From: Bernadette Owens
Sent: 01 December 2020 09:13
To: DC Support
Subject: 20/02779/REM

From: Tim Screen <Tim.Screen@Cherwell-DC.gov.uk>
Sent: 30 November 2020 16:24
To: Bernadette Owens <Bernadette.Owens@Cherwell-DC.gov.uk>
Subject: RE: 20/02779/REM

Phase 1 Landscape Management and Maintenance Plan

Figure 4.2. Landscape Proposals Around Buildings

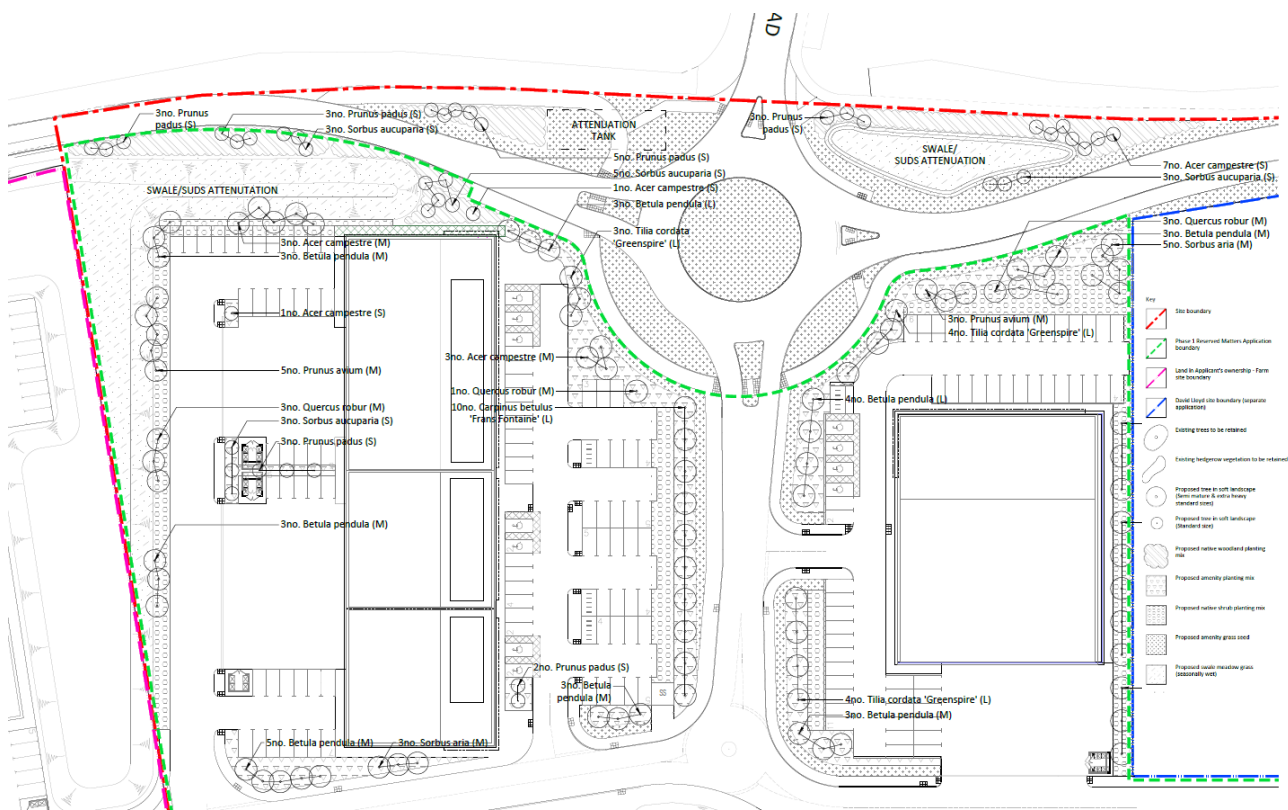
The 20 - 25 cm girth Tilia tree are supplied and planted to provide maximum visual effect on either side of the highway access, but they may not achieve the ultimate mature height unless the appropriate amount of water is provided to establish them: root growth can be checked resulting in restricted growth of canopy. Smaller nursery supplied trees at 16 – 18 cm girth are recommended but they require the appropriate amount of watering – refer to the LMMP specification above.

Delete and P. padus in favour of Acer campestre because cherry trees do not thrive in water retentive heavy soil.

Betula pendula will eventually damage and crack paving and kerb. I recommend that they are planted at least two away from kerb and root deflectors installed.

The roundabout is will be quit open and uninteresting. This is the opportunity plant attractive feature trees that unify the road frontage of Phase 1, and for the benefit of pedestrians reduce the scale and make the area more intimate. I recommend that a highway vis-splay compliant landscape scheme. A highway/landscape maintenance parking bay is necessary for the safety of operatives

What is the proposed bottom of swale meadow mix? It is not indicated.

Figure 4.3. SuDS Swale Landscape Proposal

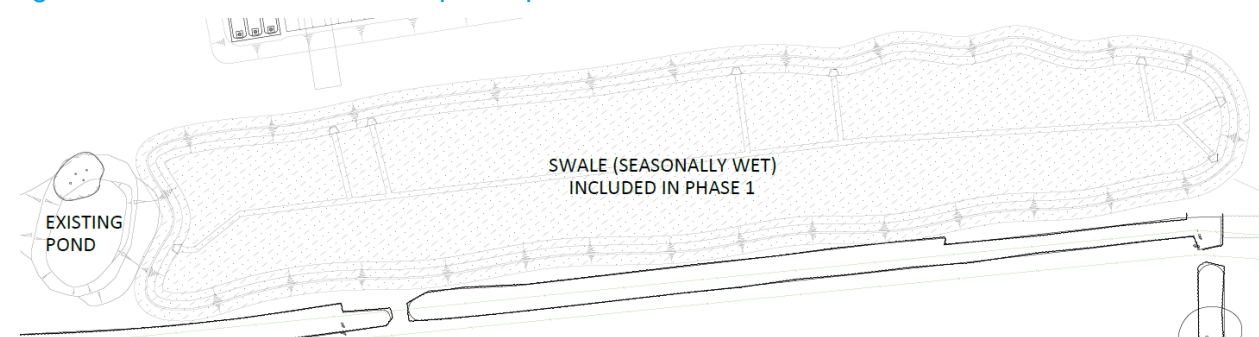
What is the proposed bottom of swale meadow mix? It is not indicated.

I assume the landscape proposals will be submitted as part of phase 2 or will this be part of Phase 2?
